From: Speakman, Glenn - Oxfordshire County Council
<Glenn.Speakman@Oxfordshire.gov.uk>
Sent: 06 May 2022 11:47
To: James Kirkham; DC Support
Cc: Transport CDC Minor
Subject: 21/00922/OUT Land West Of Foxden Way Great Bourton OX17 1QY

Planning application:	21/00922/OUT
Location:	Land West Of Foxden Way Great Bourton OX17 1QY
Description:	OUTLINE Planning Application with all matters reserved save for access for up to 9 First Homes
Case Officer:	James Kirkham

In our previous response to this application, we objected to the granting of planning permission. The application has since been amended. I have assessed how the updated plans impact our previous reasons for objection:

REV	DESCRIPTION	DATE	BY	AUTH
B	FOOTPATH ALIGNMENT REVISED TO MEET CLIENT REQUIREMENTS	12.01.22	JP	GM
A	ACCESS UPDATED FOLLOWING UPDATE TO MASTERPLAN	18.10.21	JP	GM

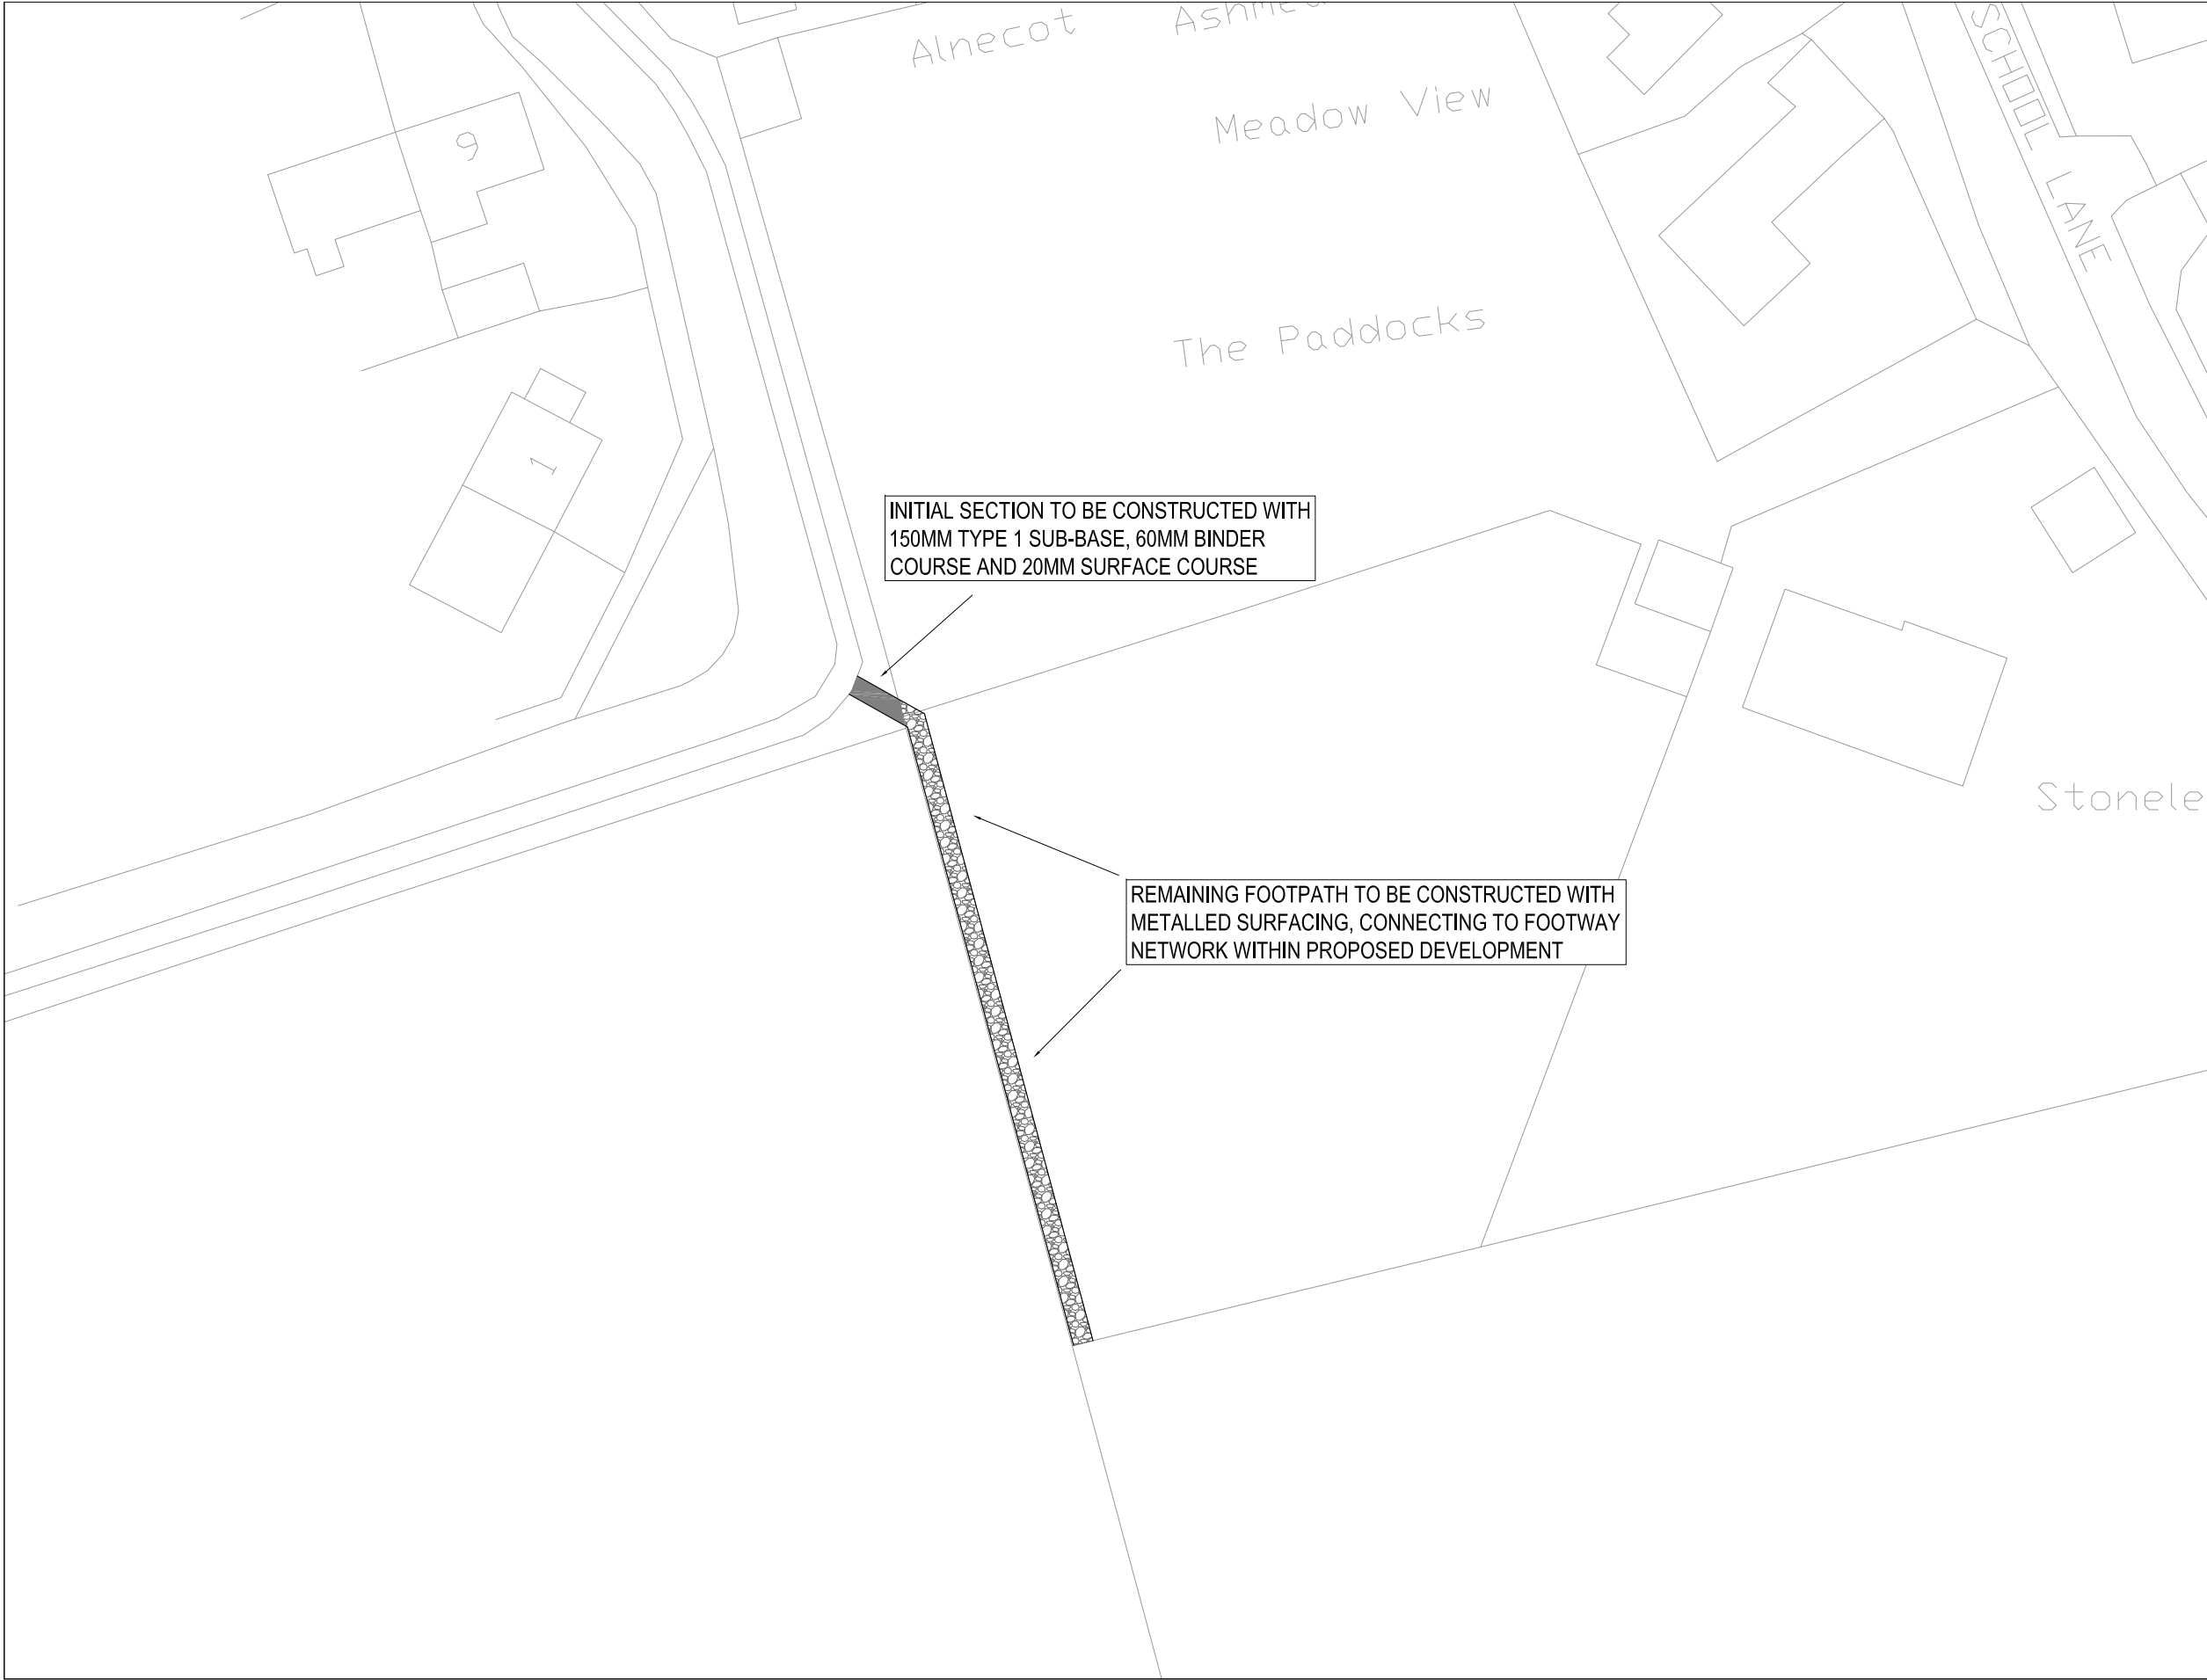
Pedestrian access: The previous plans made no provision for additional pedestrian infrastructure. The new plans propose a 2m wide footpath connecting the site to the southern allotments via Foxden Way. An additional pedestrian link is also proposed connecting the rear of the site to South View.

The new link to South View should be 2m in width and of materials suitable for vulnerable road users such as those using prams, wheelchairs, etc. If a 2m width is not achievable, further details should be provided demonstrating that the new path isn't bordered by obstacles such as fences or hedgerows. This should be obtained via planning condition.
